**ADC Planning Consultation
Conservation/Design Officer Response**

Application Number	WA/44/17/OUT
Address	Land to the east of Tye Lane, Walberton
Description	New residential development affecting the settings of designated heritage assets
Case Officer	Michael Eastham
Date	19 July 2017

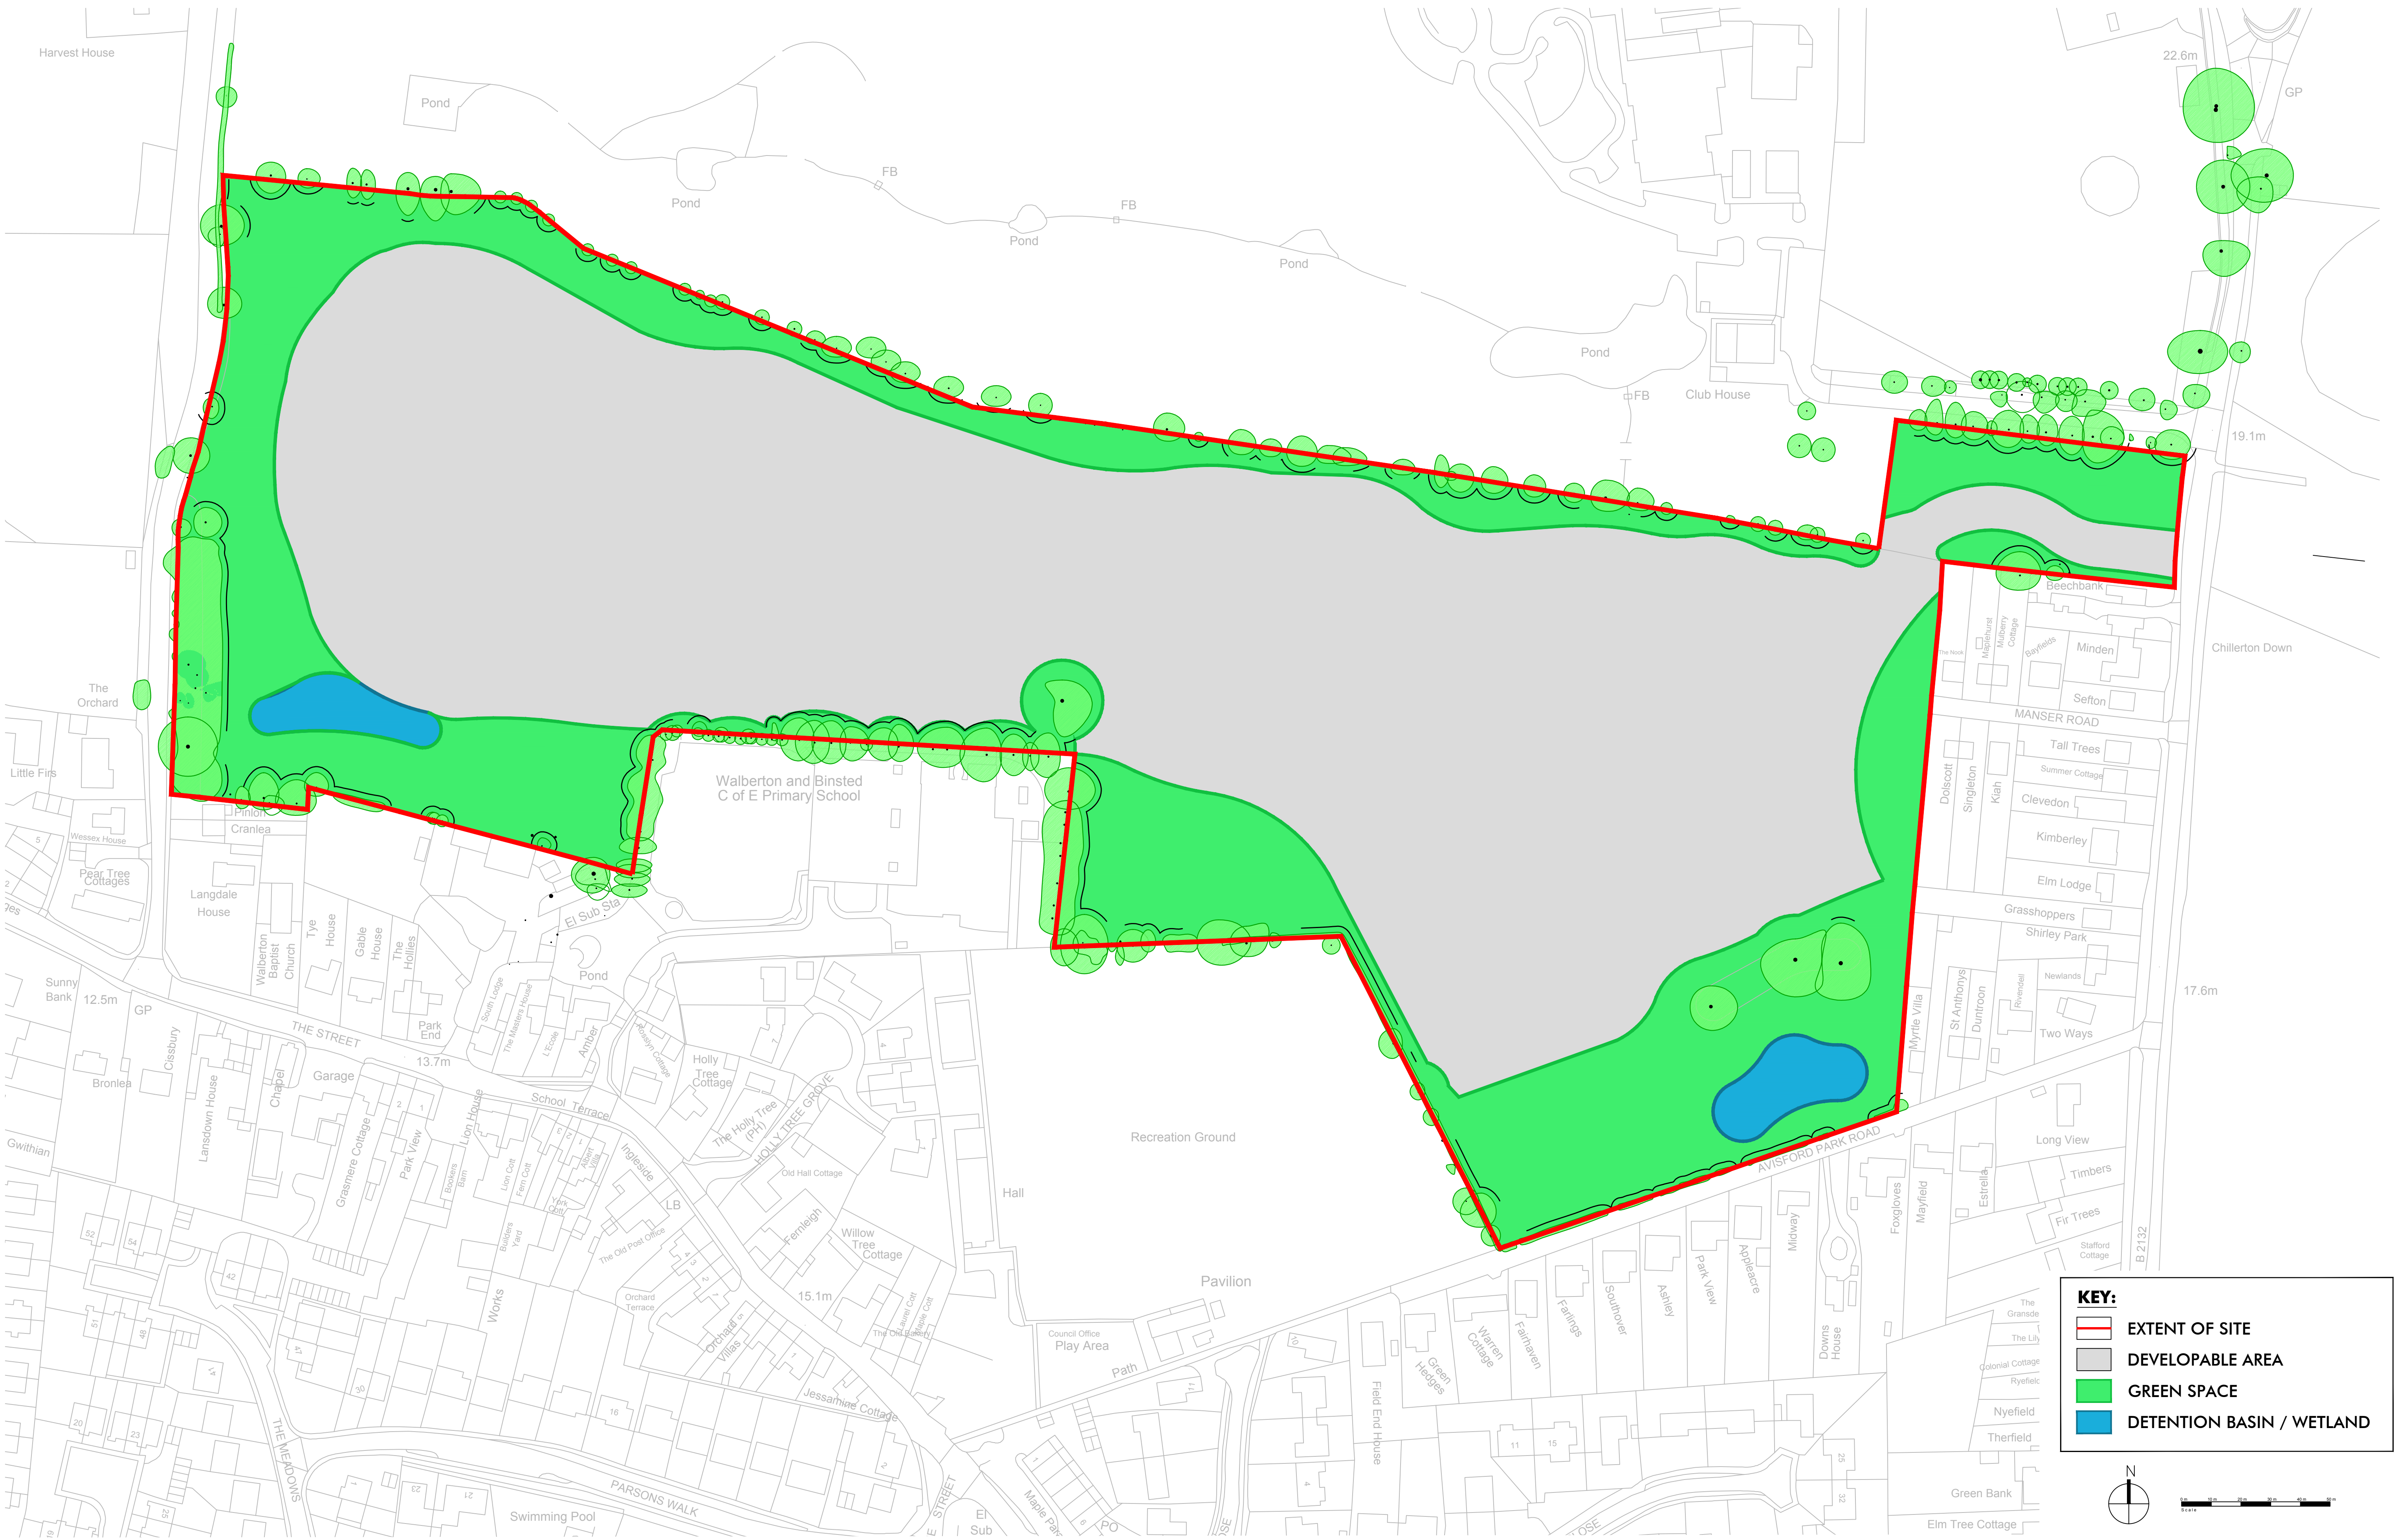
It is noted that the outline proposal seeks permission for up to 175 dwellings, which is a welcome reduction from the figure of up to 200 proposed at pre-application stage. However, the reduction is not evident when comparing the site layouts of the preliminary and outline proposals, as there appear to be less open green space and a more intensive form of development in the current scheme. It is also noted that the DAS (p45) refers to the new built form being 'no higher than 2 storeys', while the Building Heights drawing (2507-A-1402-A) shows the buildings with a ridge height of up to 9m, which suggests three storeys. It is questioned whether three storey development is appropriate to the local context, where village buildings are modestly scaled and rarely exceed two storeys.
